CITY OF ALBUQUERQUE

February 22, 2017

**Re: Shopping Center
1220 Eubank Blvd. NE
Request 30-Temporary C.O. - Accepted
Engineer's Stamp dated: 3-11-16 (J21D045)
Certification dated: 1-26-17**

(ENGINEER'S CERTIFICATION) JANUARY 2017

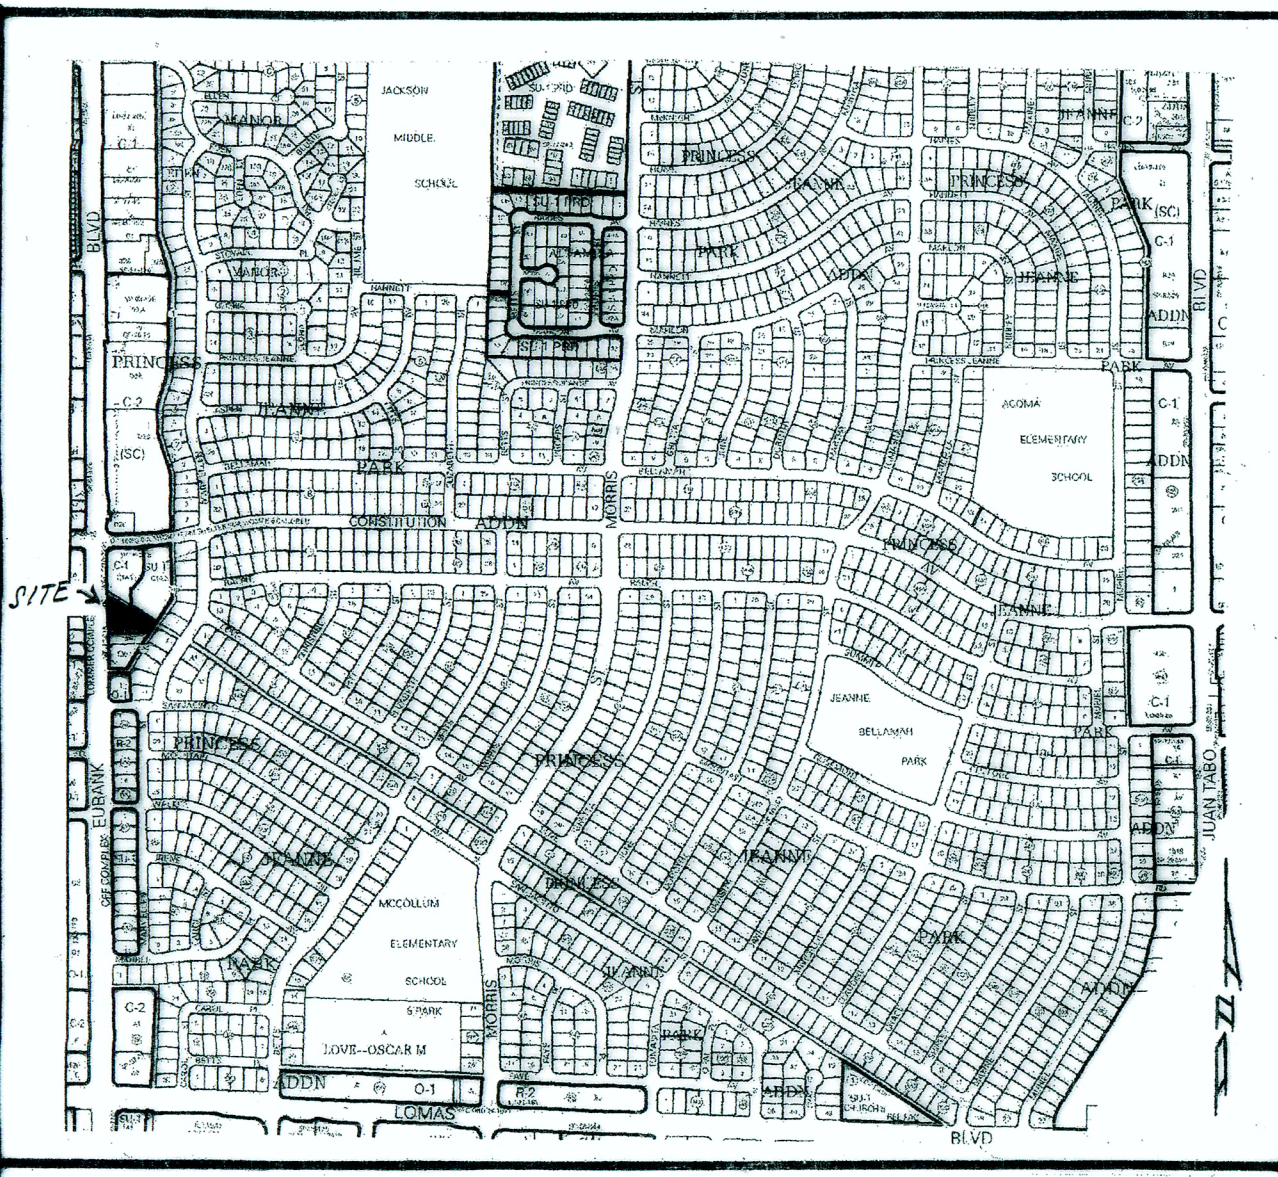
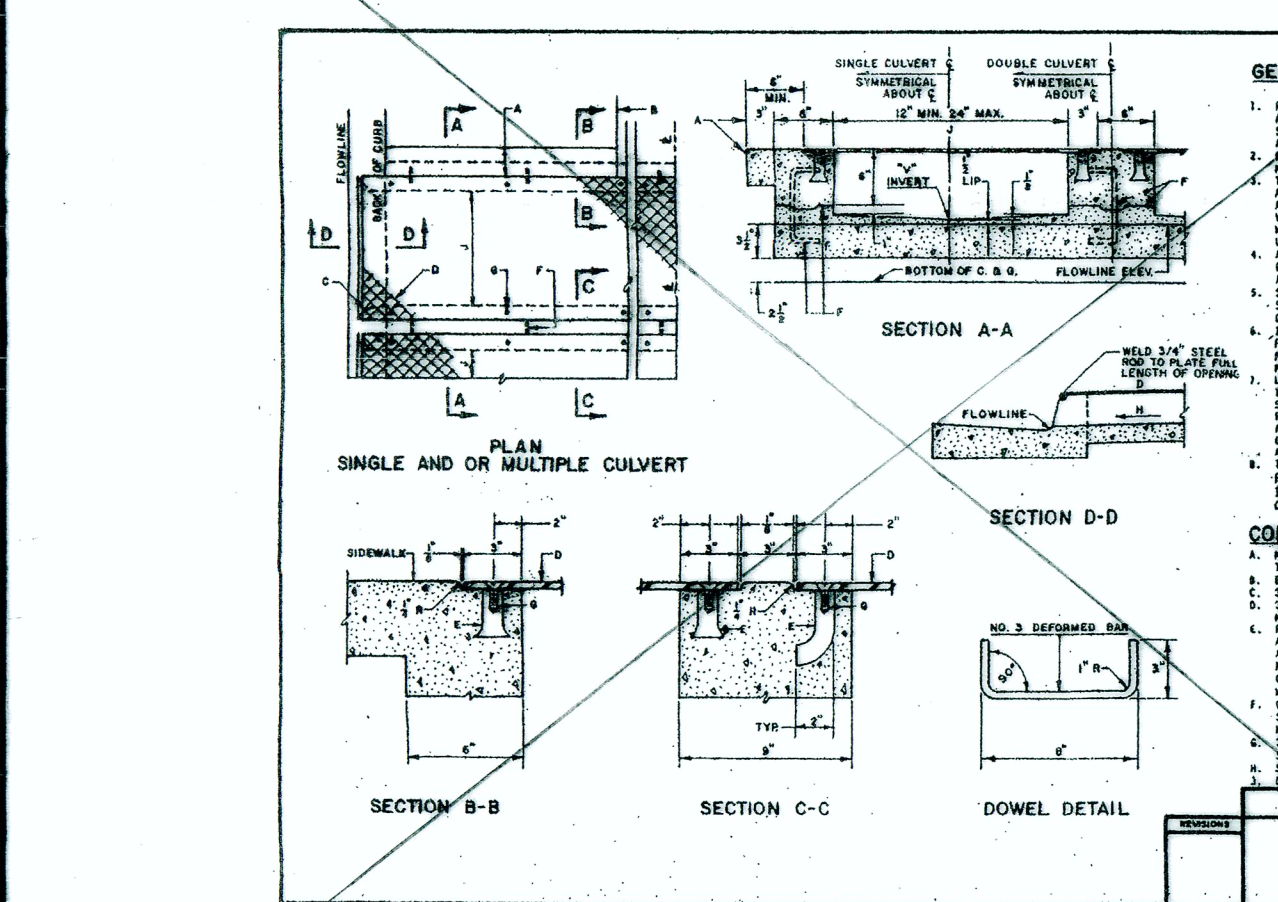
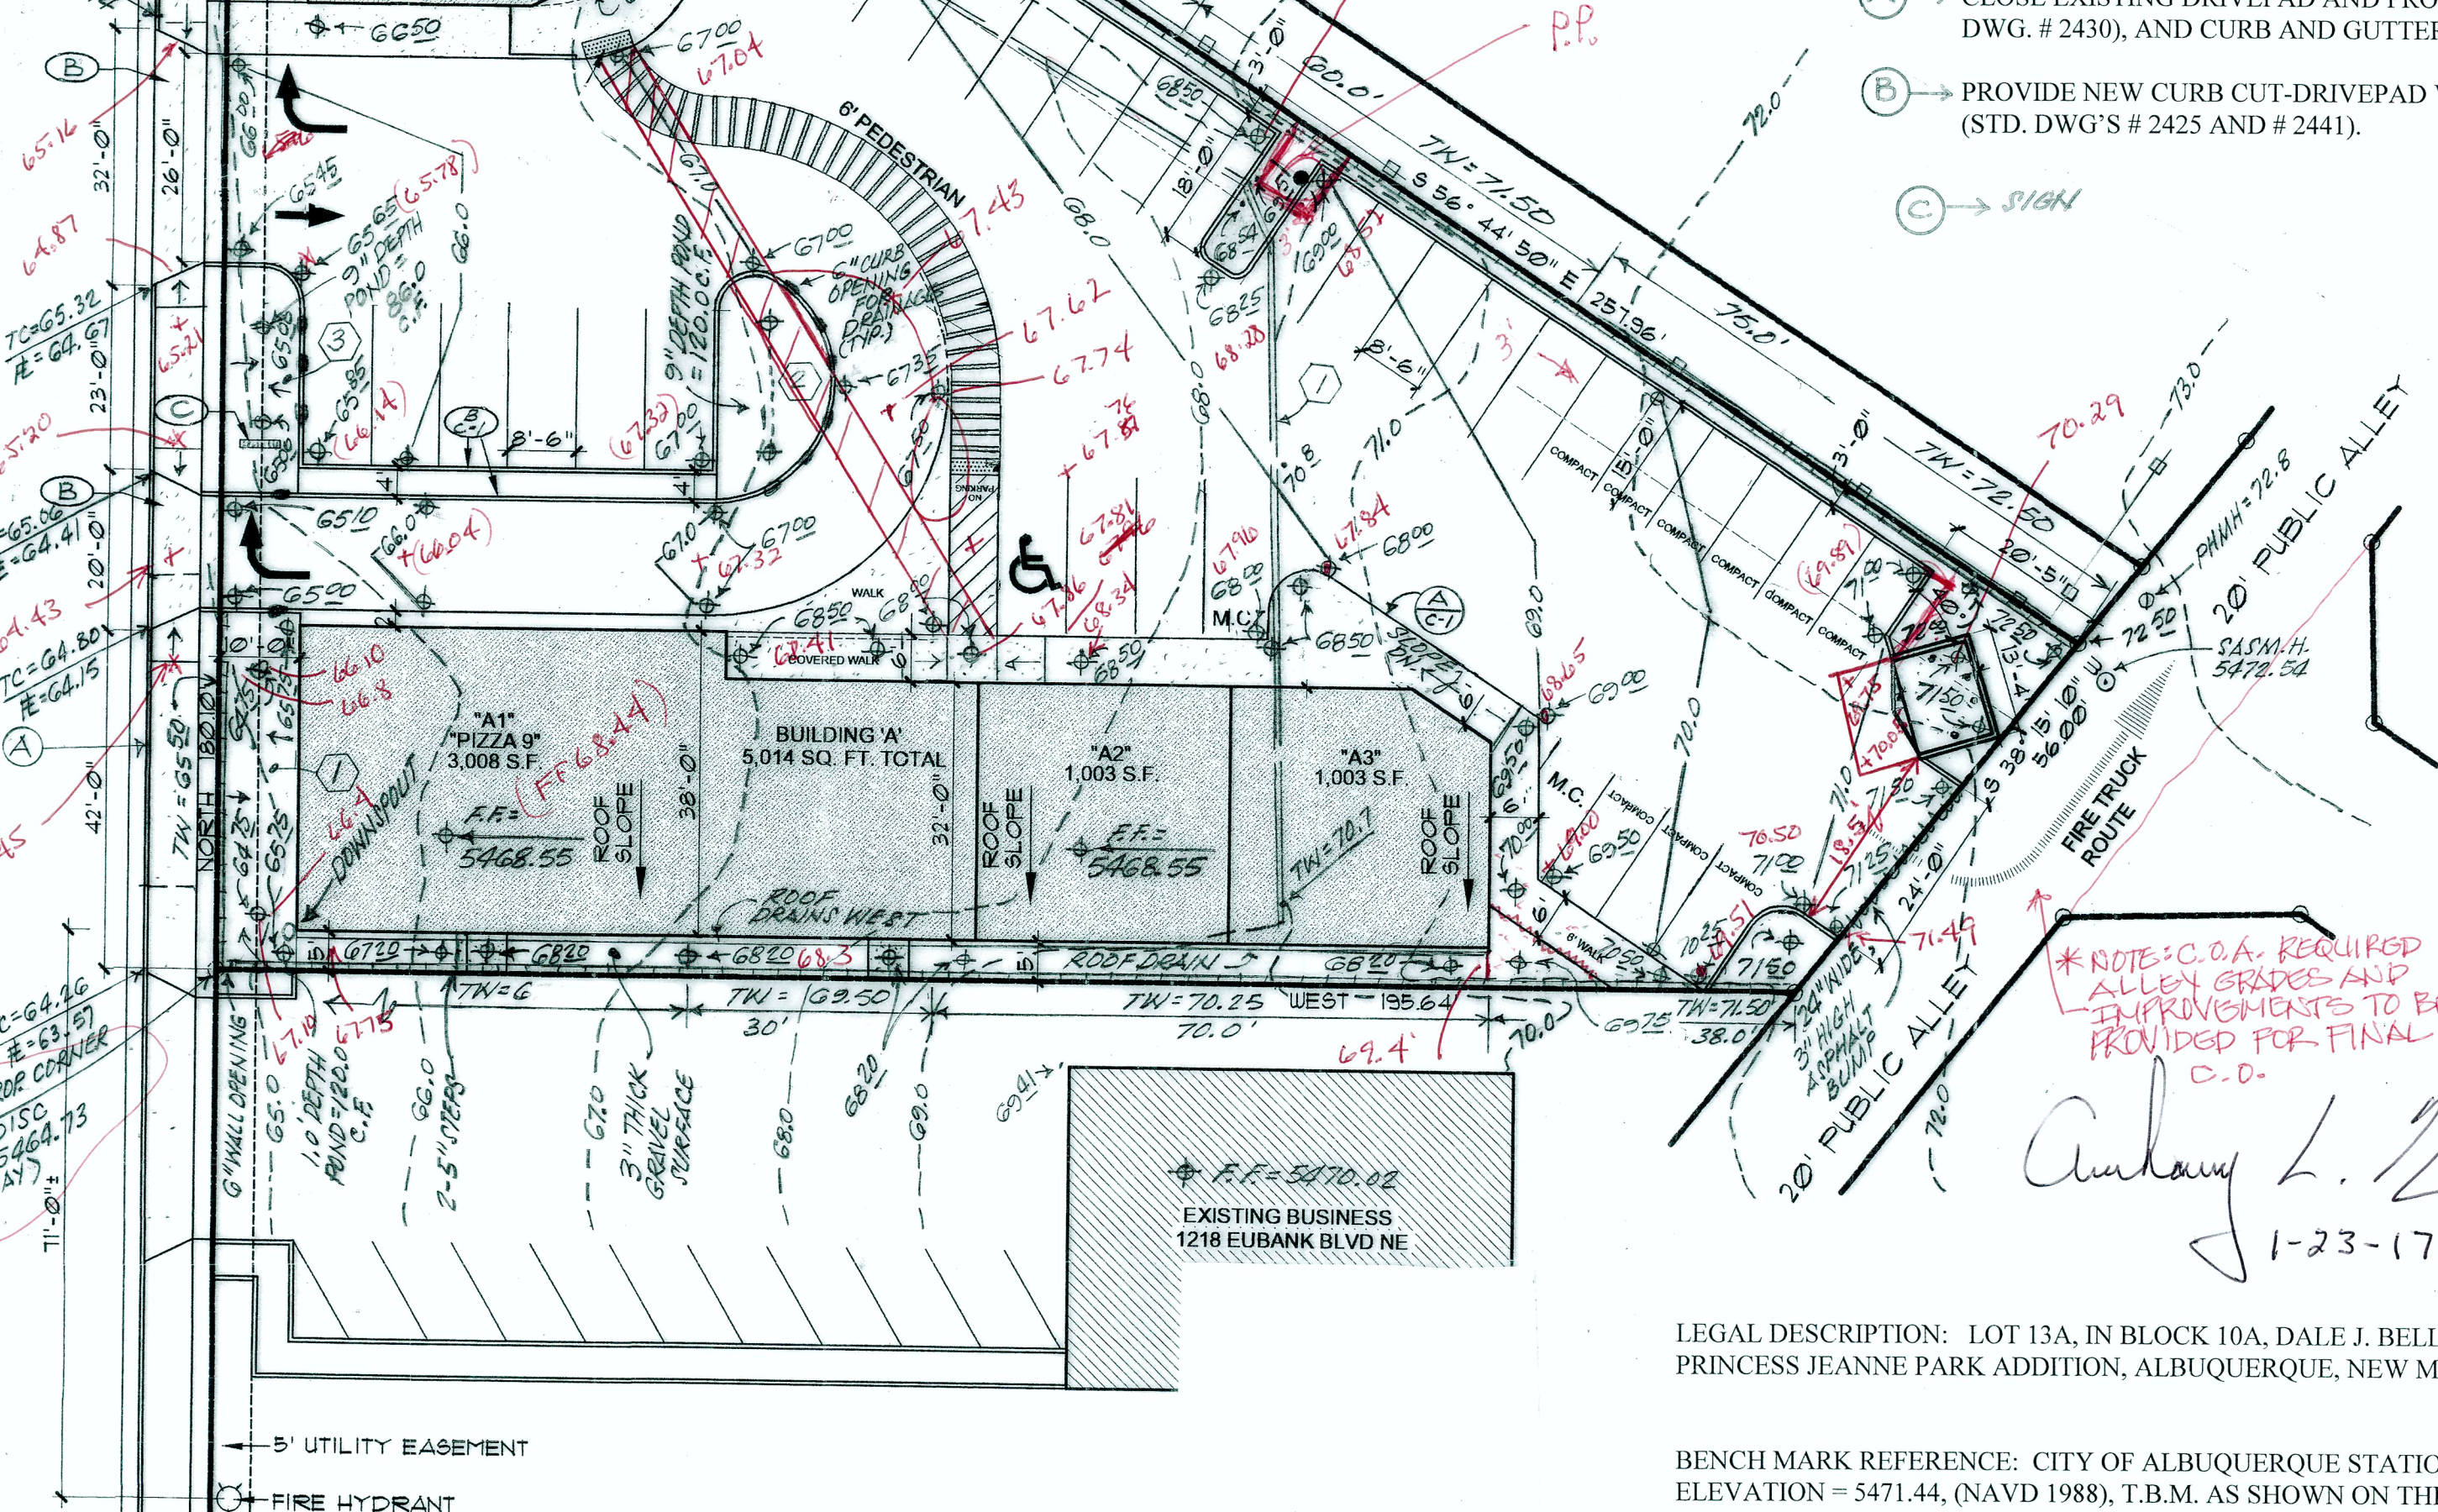
- Alley grades and improvements to be provided. Submit plans thru DRC for approval.
- Pond #1 grades need to be corrected.
- Remove notes referring to pond #2.
- Remove note #1 referring to existing retaining wall.
- Correct drainage on north side against building B.
